**Re: Wal-Mart at 4700 Cutler, Administrative Amendment Request, Project #PR-2021-005016**

Please find responses below in bold addressing the Transportation Development Comments received February 18, 2021.

DEMOLITION & SITE PLAN  
SHEET: CS1

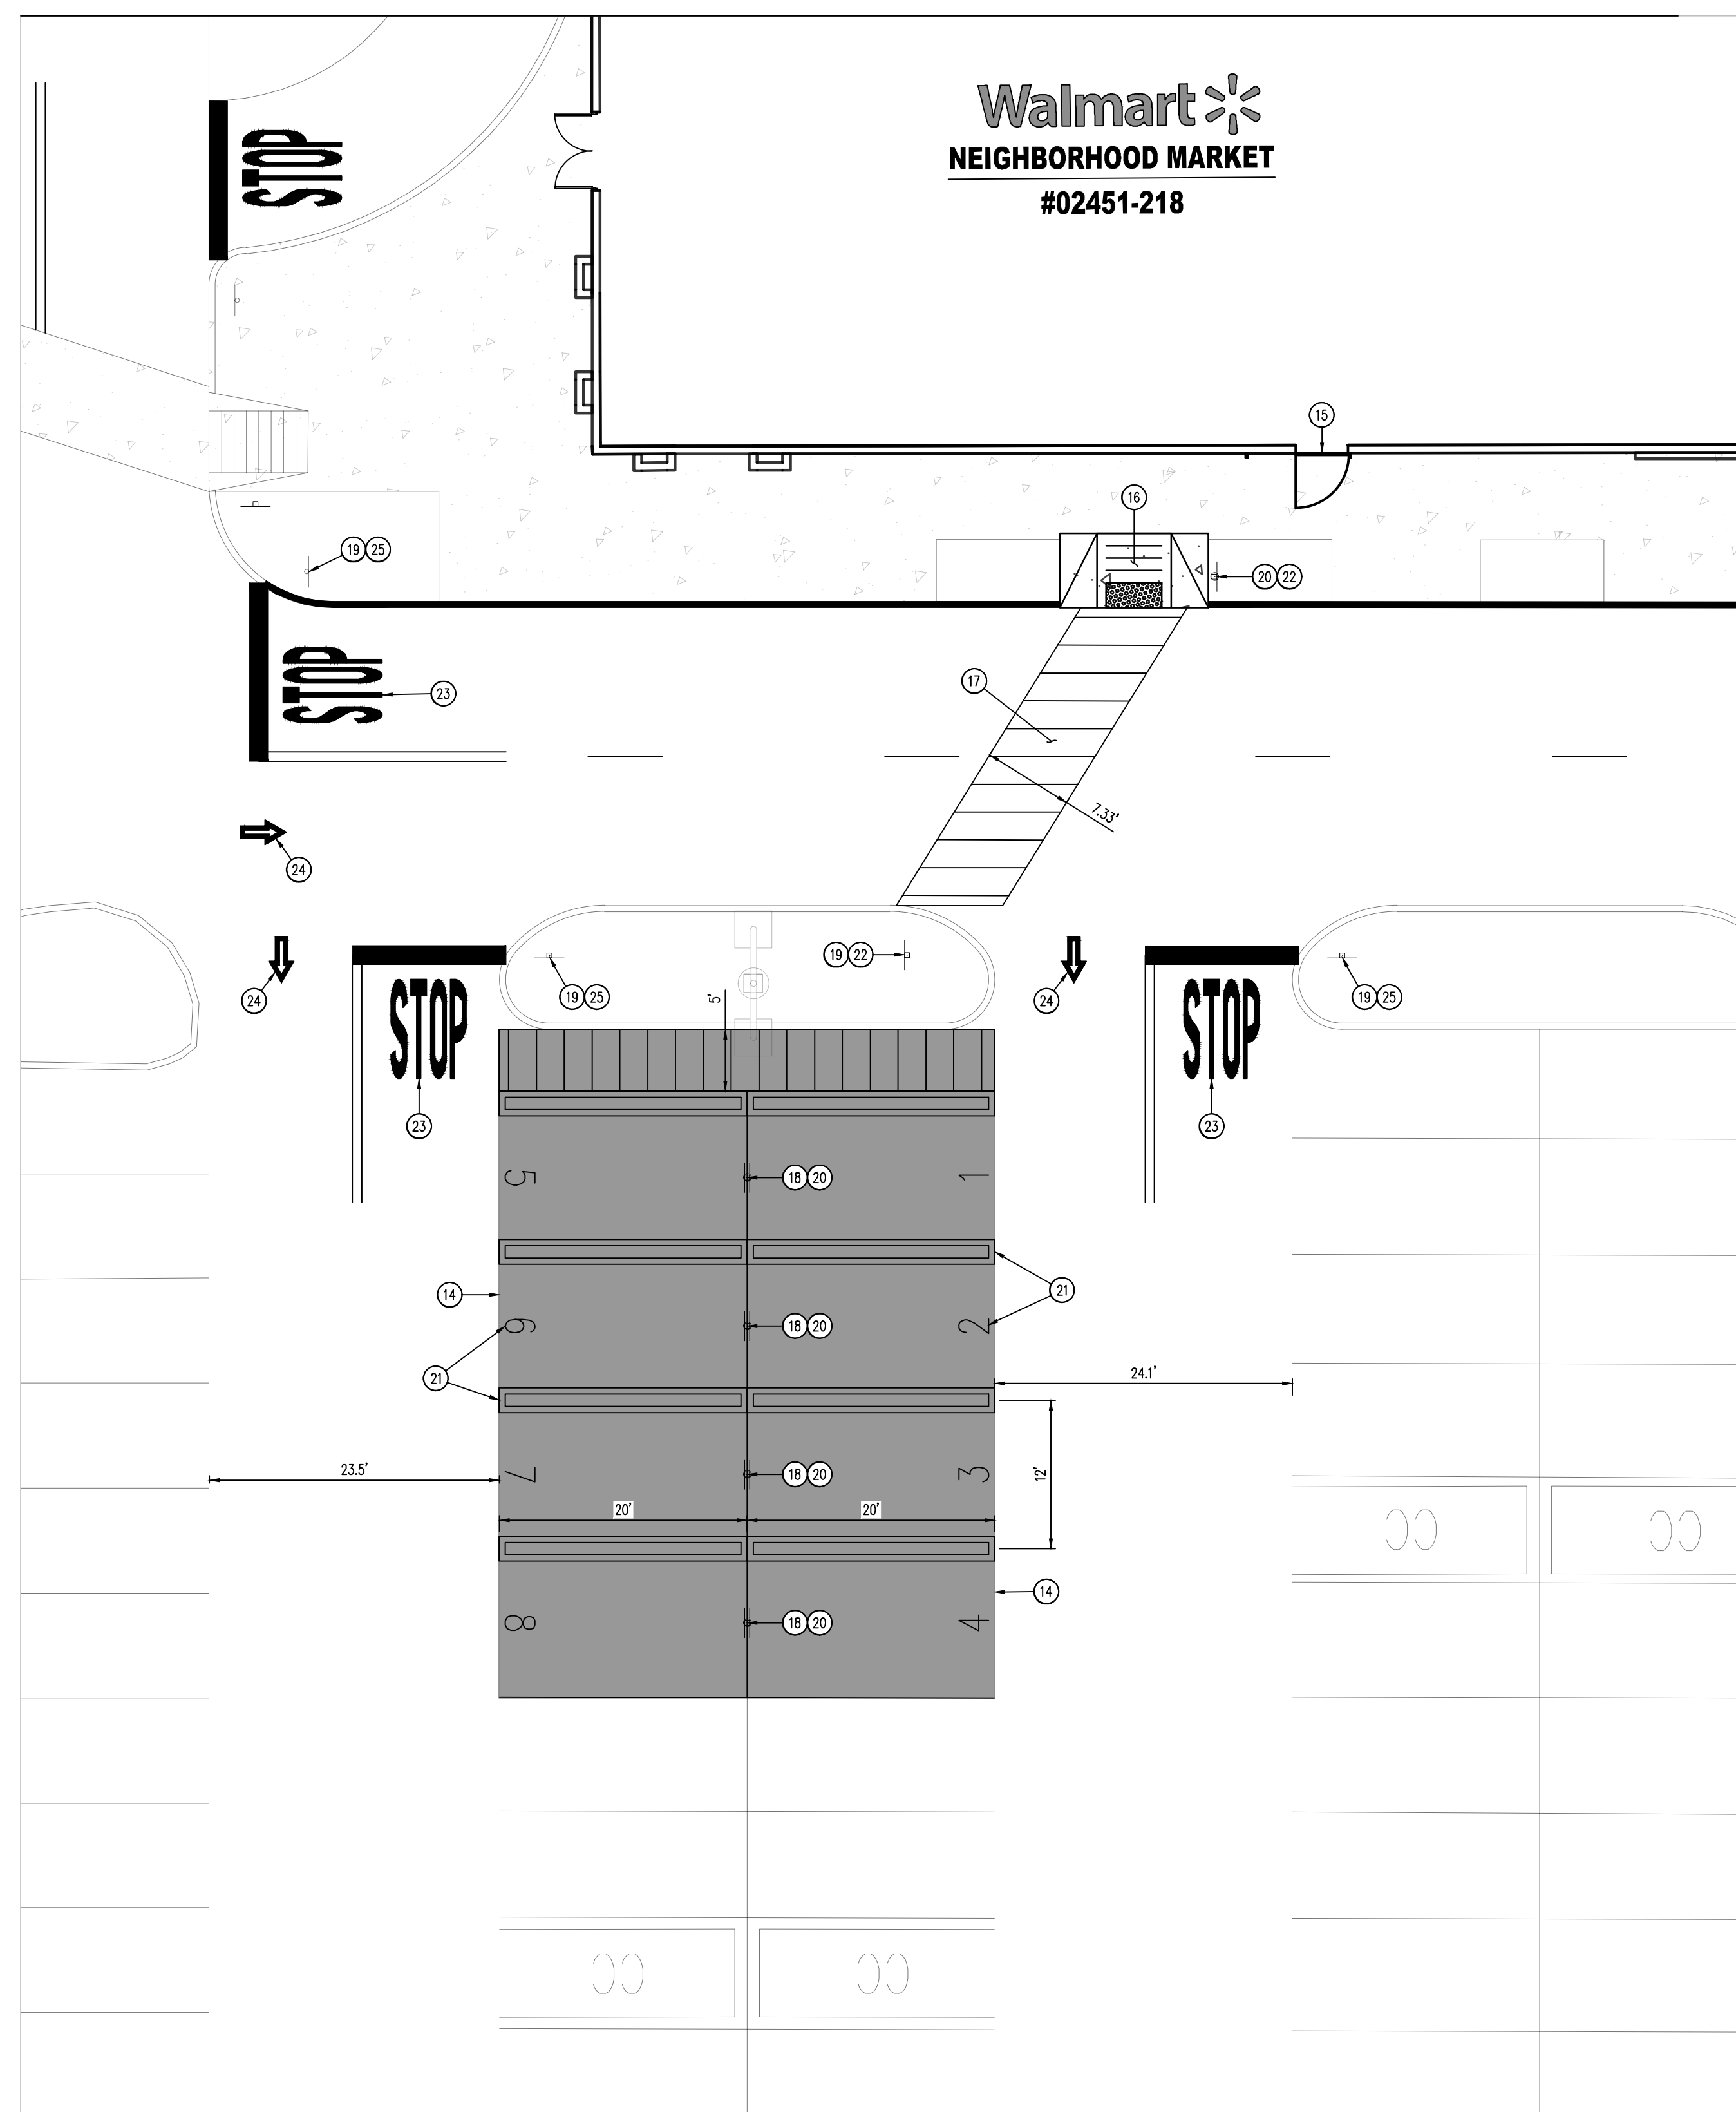
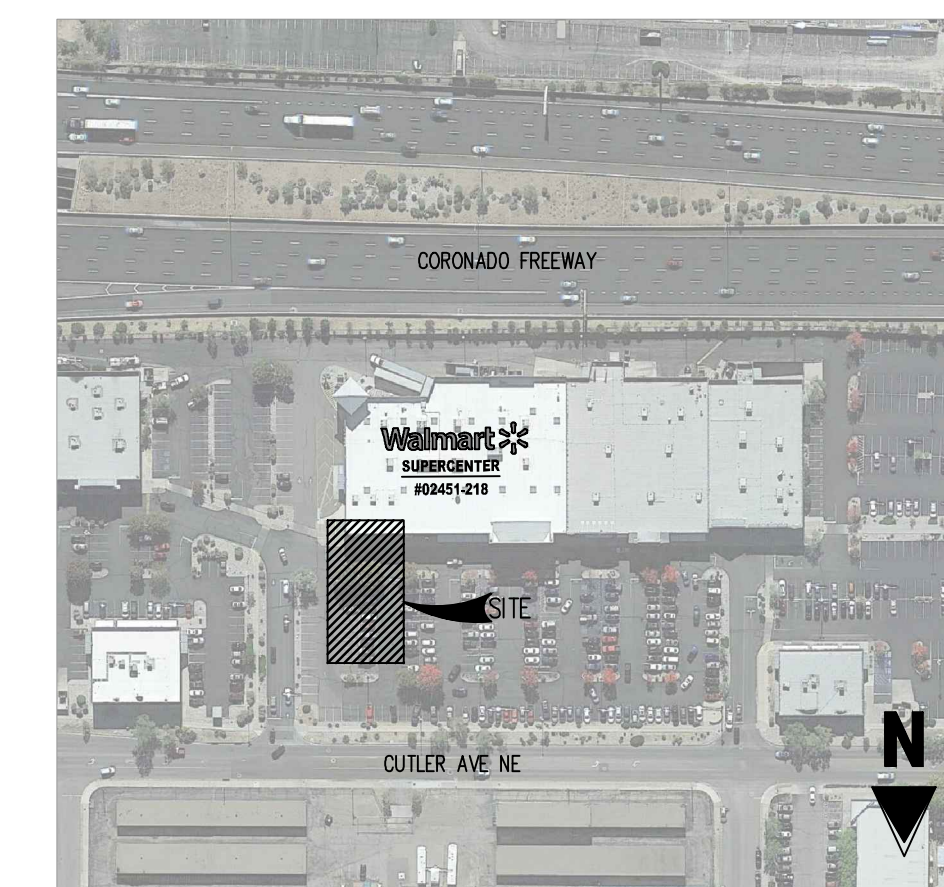
3. In the package, I did not see any details for signage and striping or a plan for parking spaces that involve pick-up only, similar to the other Wal-Mart packages. Please make sure to provide all plans.

**Response: Requested sheets were issued with Addendum #2 on 2-25-2021 and will be included as necessary with any subsequent submittals.**

SSM-1

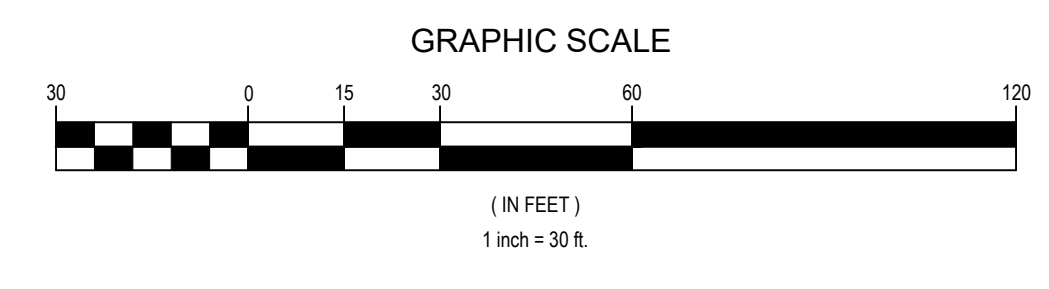
1. For centerline striping, ratio of the gap to the stripe should be 3:1.

**Response: Centerline is a 4" wide yellow stipe 6' long with 18' gaps, per Schedule Note Z on sheet 6020 – SECP-1 Demolition & Site Construction Plan, providing a gap to stripe ratio of 3:1.**

2. Provide "Yield to Pedestrian" signage on either side of the main crosswalk entrance per MUTCD requirements.

**Response: "Stop Here for Pedestrians" signage (R1-5b) is shown on either side of crosswalks, per Schedule Note R.**
